DECISION DELEGATED TO DEVELOPMENT MANAGER

Application No: H11-1007-19 **Applicant:** Mr R White
Proposal: Caravan park reception/office and manager's house
Location: Vicarage Lane Long Sutton Spalding
Terminal Date: 5th June 2020

First Floor Plan (1:100)

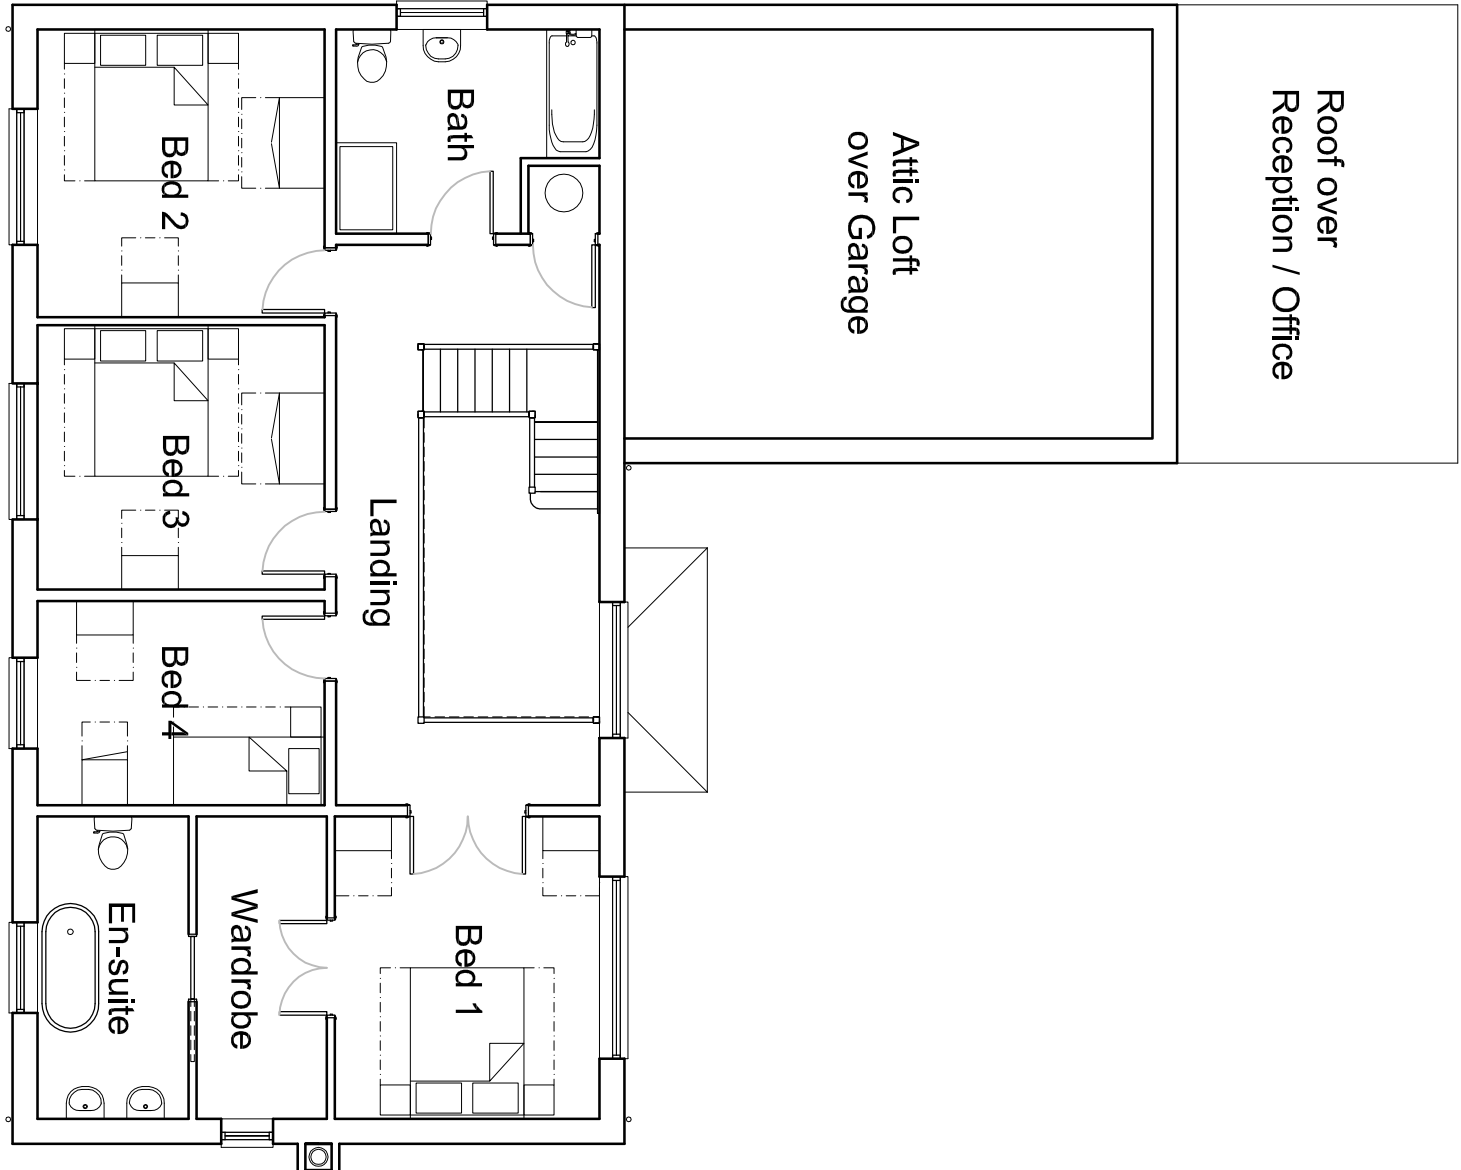
The footprint of the development shows that the property will have a L shape. The building will measure approximately at maximum 19.15 metres in depth, 15.1 metres in width and 8 metres in apex height. The eaves will be 4.75 metres high. The resulting scale and height will be significant excessive in view of a few low buildings in the area, The Hamber (west) and No. 59 (east).

From the front wall, the most protruding part will be a single-storey high pitched element but still subservient to the ridgeline of the house. It will accommodate the caravan park reception and office as well as double garage for the dwelling occupiers. Communal spaces will be located on the ground floor whereas 4 no. bedrooms will be on the first-floor level.

In summary, the material schedule and detailing is acceptable but the building will constitute an intrusive element that would be detrimental to the prevailing rural character of the countryside. The development will be excessive in relation to the few existing buildings in the locality by reason of scale and height. The proposals therefore are contrary to the aforementioned policies about design, layout and character of the local area.
